From: Jane Tucker
Sent: 25 May 2023 15:20
To: Planning
Cc: Ben Taylor
Subject: FAO Ben Taylor Wiswell Parish Response 3/2023/0289 at Fair view Pendleton Road Wiswell BB7 9BU

Comments on the revised/second planning application.

project	project number	drawing number
fairview	22.68	pl.20
name	proposed site plan and garage elevations	revision
scale	date	status
1 to 100 @ A1	april 2023	planning
revision		B

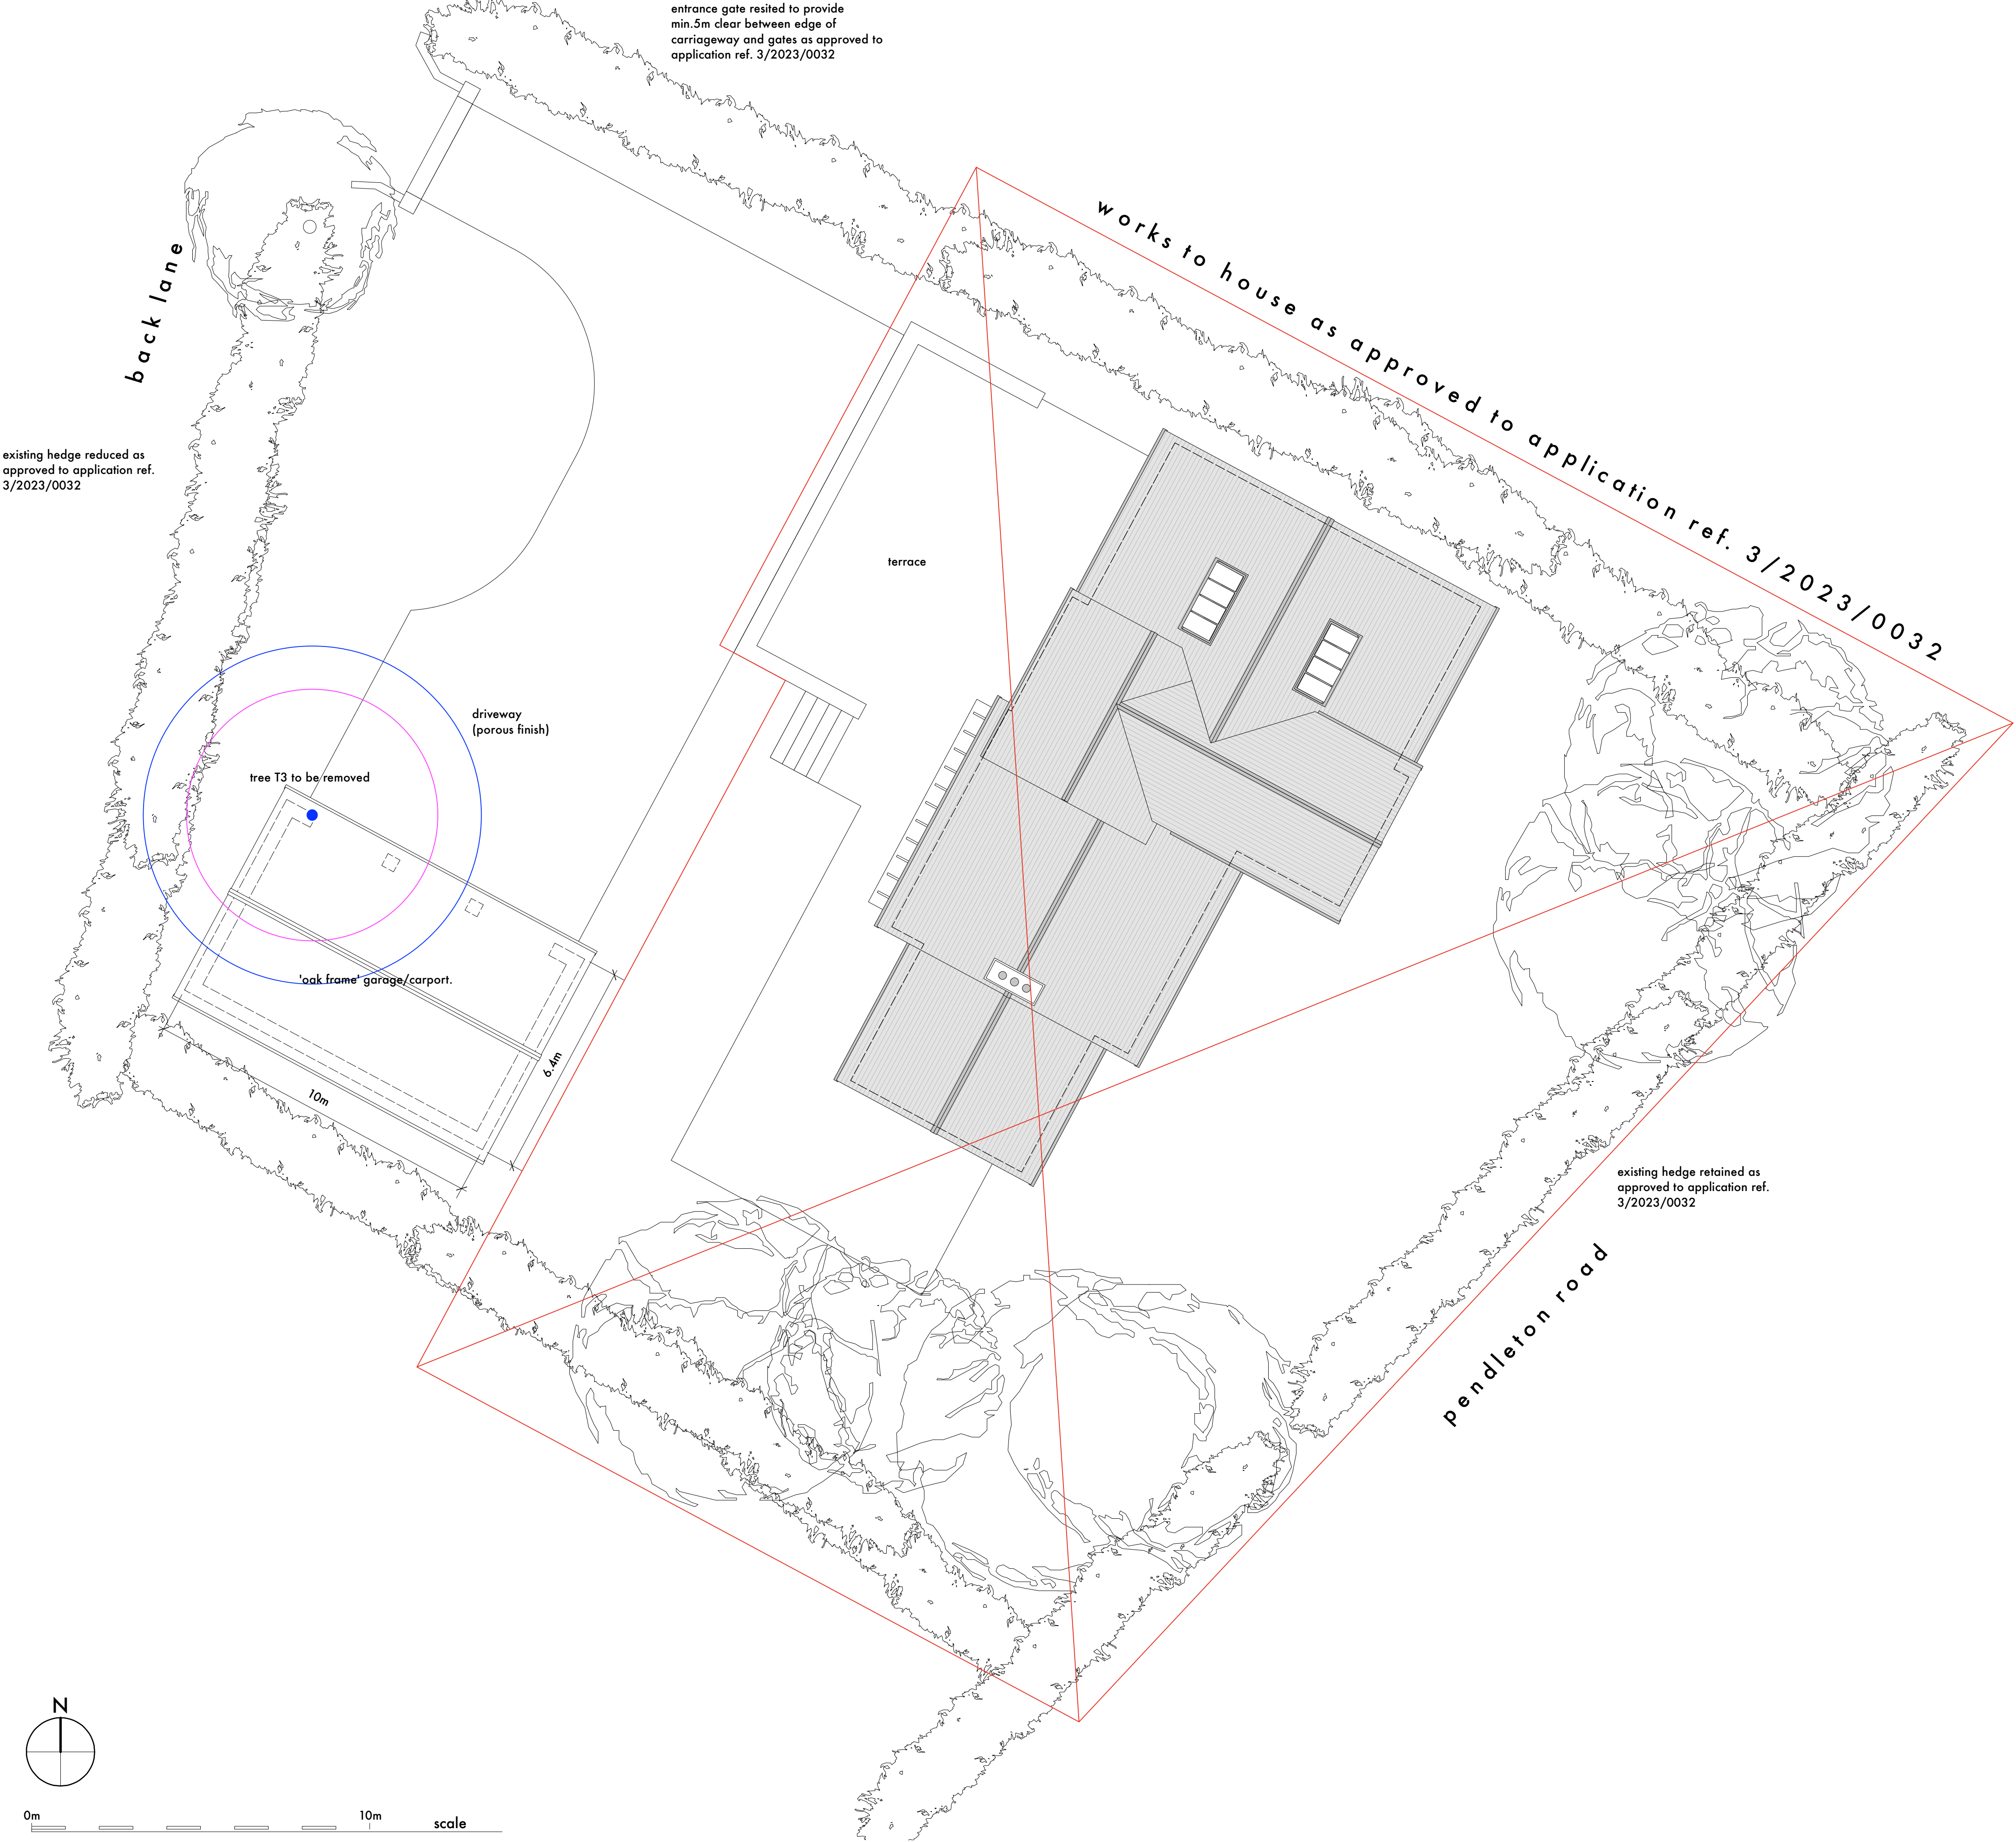
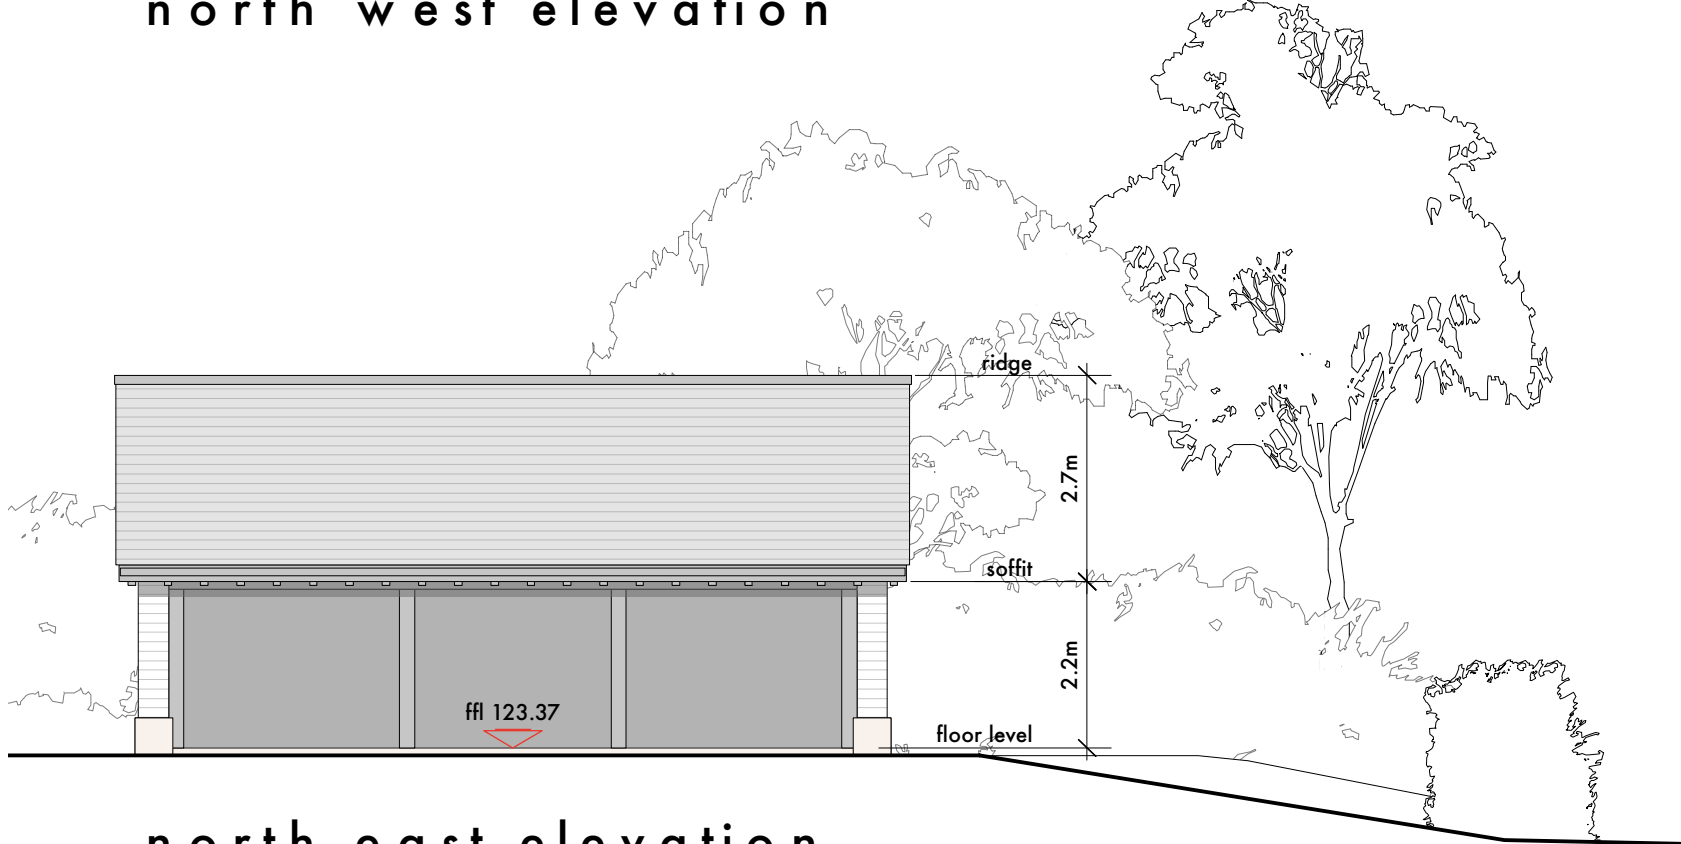
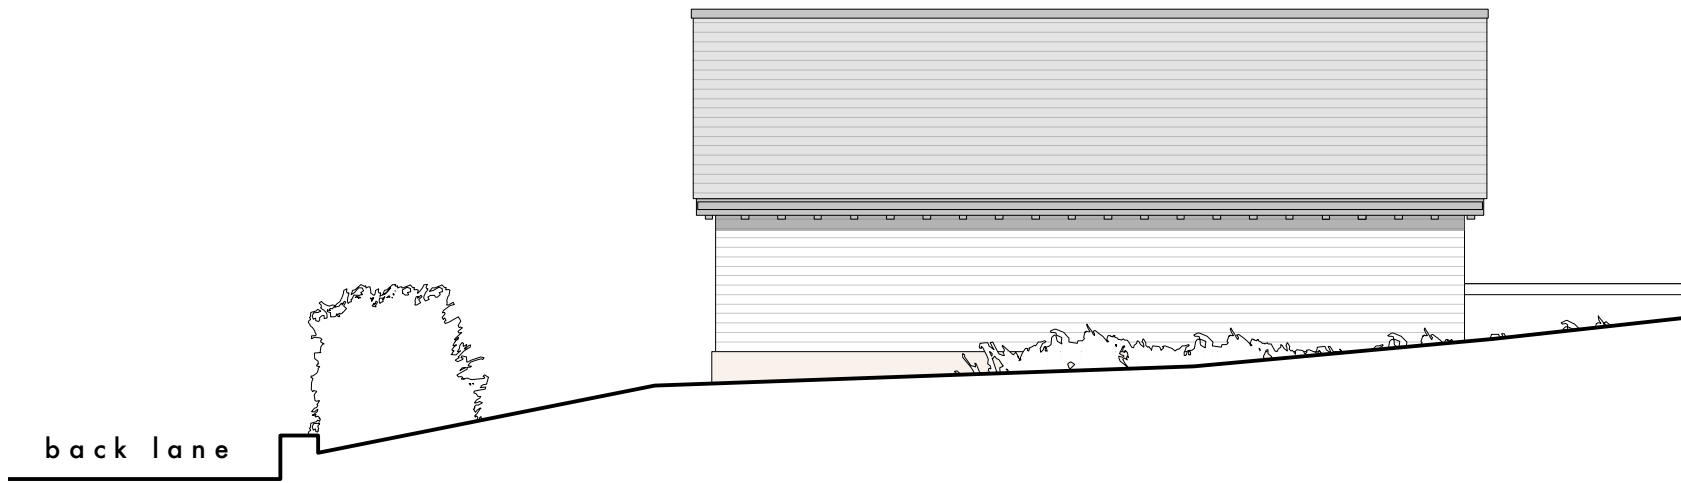
1. There does not seem to be a definition of level for the garage block in relation either to the road surface or to the existing house. This is essential to control the visible height which is a relatively significant addition in the Conservation Area.
2. To avoid reversing out onto Back Lane (with the poor visibility), it should be confirmed that there is a sufficient turning area is maintained on the drive.
3. The heights of the hedges facing Pendleton Road and Back Lane are not shown accurately on the elevations. They are significantly higher than shown, particularly on Back Lane. Does this mean that it is proposed to reduce the hedges to the height shown? There is currently loss of light for properties on Back Lane.
